CITY OF PORTLAND

Mike Scarks
Neptune Properties
120 Exchange Street
Portland, Maine 04101
RE: 340 Cumberland Ave.
CBL: 037 f009

05/15/2001

I have recently received the stamped/engineered electrical drawings, stamped by Harold Thomas, from Mancini Electric for the Internet Hotel @ 340 Cumberland Avenue.

SHEET :
A-1

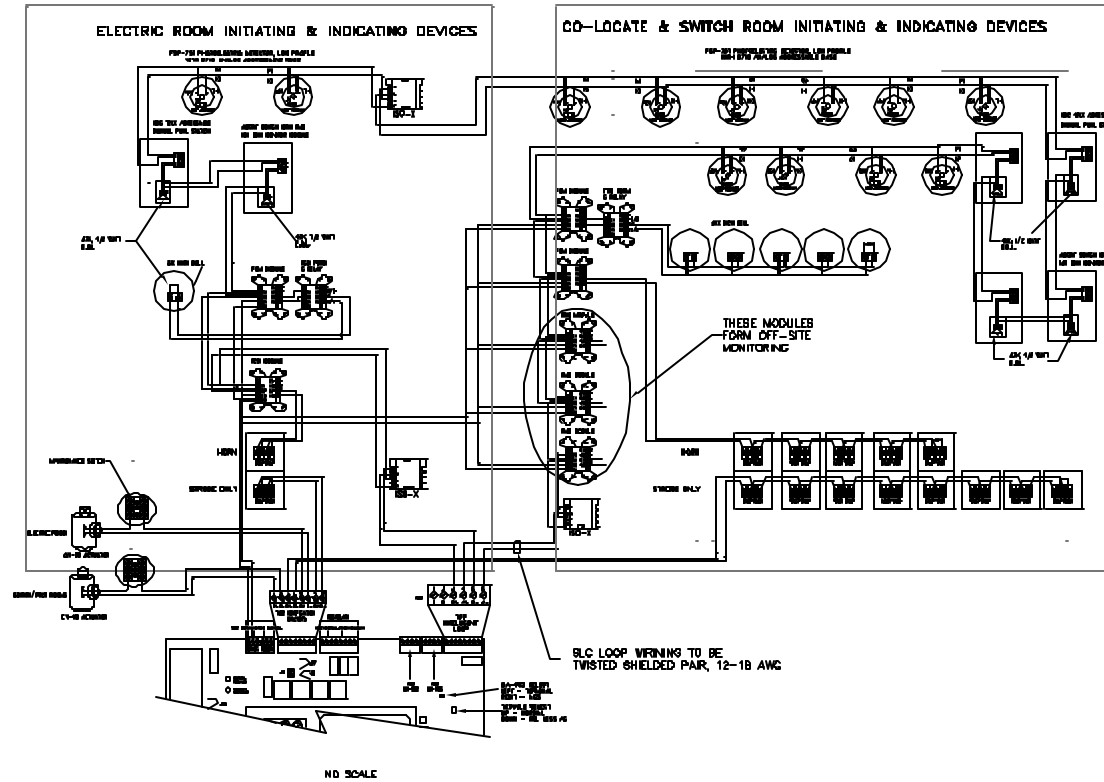
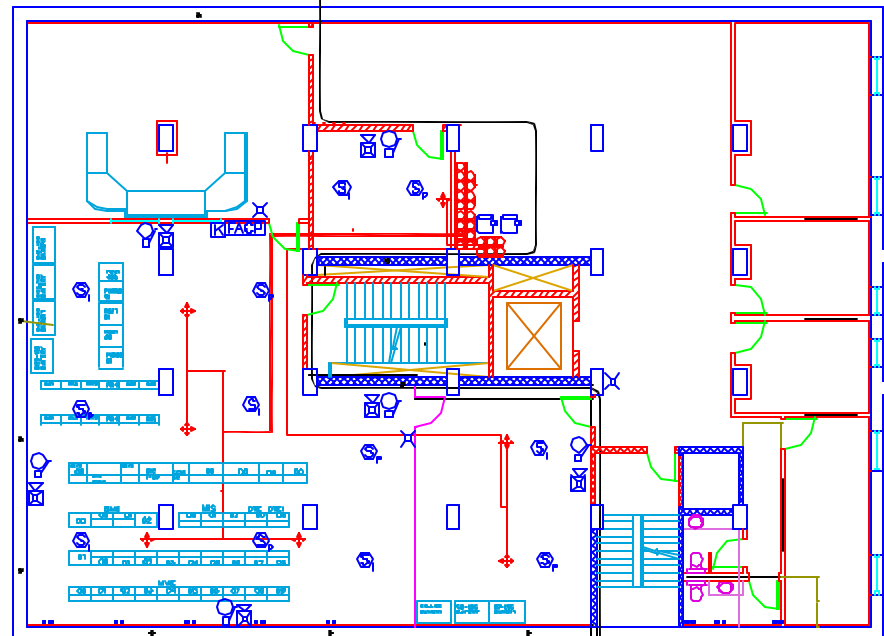
The drawings have been reviewed by myself and have met with my approval. The drawings do not reflect the existing 600amp, 3 phase 120-208volt service. **Only one service is allowed to serve this building. The existing service is hereby condemned due to its unsafe condition.**

Therefore the existing service shall de-energized and eliminated, in order to facilitate the installation of the new 3000amp, 3 phase 277-480 volt service, pursuant to the following articles of the 1999 NEC.

ARTICLE 90-1: Practical safeguarding
ARTICLE 90-4: Enforcement
ARTICLE 110-11: Deteriorating Agents
ARTICLE 230-2: Number of Services

The new service entrance shall not become energized until the existing service entrance has been eliminated. Please feel free to contact me if you have any further questions concerning this matter.
